**Reserved Matters Approval 18/01309/REM – Discharge of Condition 4 (Materials) - Planning Portal Ref PP-09300895 – Development at Cotefield Farm Bodicote**

OXFORD ROAD, BODICOTE – MATERIALS PLAN – PHASE 2

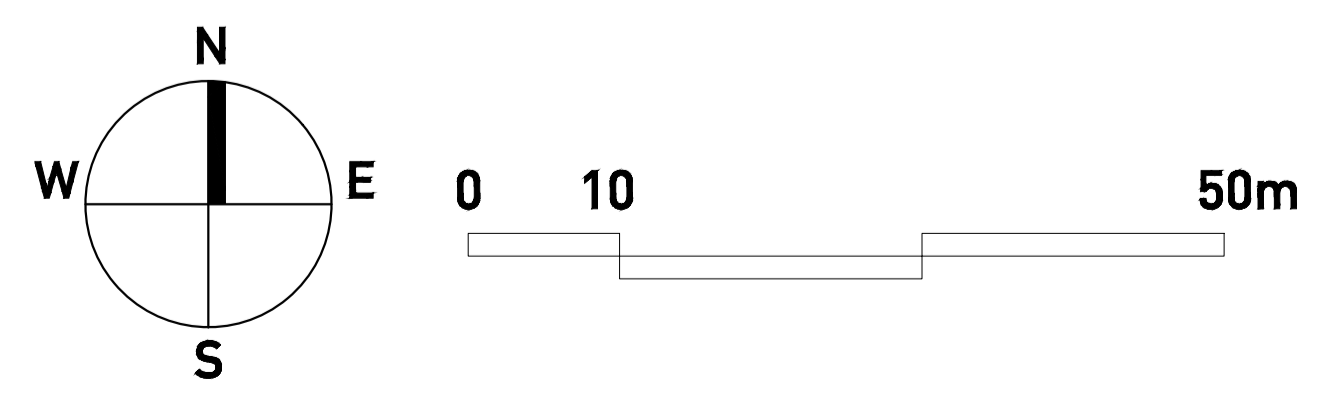
The condition was originally discharged in early 2019 (ref 18/00502/DISC) and construction of Phase 2 commenced in autumn 2019. We are seeking a change to the approved materials for four of the plots (plots 82, 83, 94 and 95) which have not yet commenced from the approved stone to the approved brick for the site.

The development comprises a mix of brick and stone; plots 82, 83, 94 and 95 as currently approved are to be stone-built dwellings. It is proposed that these four dwellings are instead built from the approved Ibstock brick. We are therefore submitting Materials Plan P18-1568-**07F** for approval.

The reason for the proposal is to slightly reduce the number of stone-built dwellings on the site in order to ease construction difficulties and timescales. The stone-built dwellings take longer to construct than the brick-built dwellings and are inconsistent in terms of coursing heights and thickness, which means additional and specialist work is needed to ensure the required minimum 125mm cavity is maintained for the external wall.

Plots 82, 83, 94 and 95 are in an area of the site not yet started where most of the dwellings will be stone; they do not front onto the public open space and they are within a street scene adjacent to the neighbouring Cala site which similarly comprises a mix of stone and brick dwellings.

Changing these two pairs of semi-detached dwellings to the site-approved brick would help to speed up the projected construction timescale for the development. It would maintain the complementary mix of materials across the site whilst retaining key frontage and corner plots as stone.
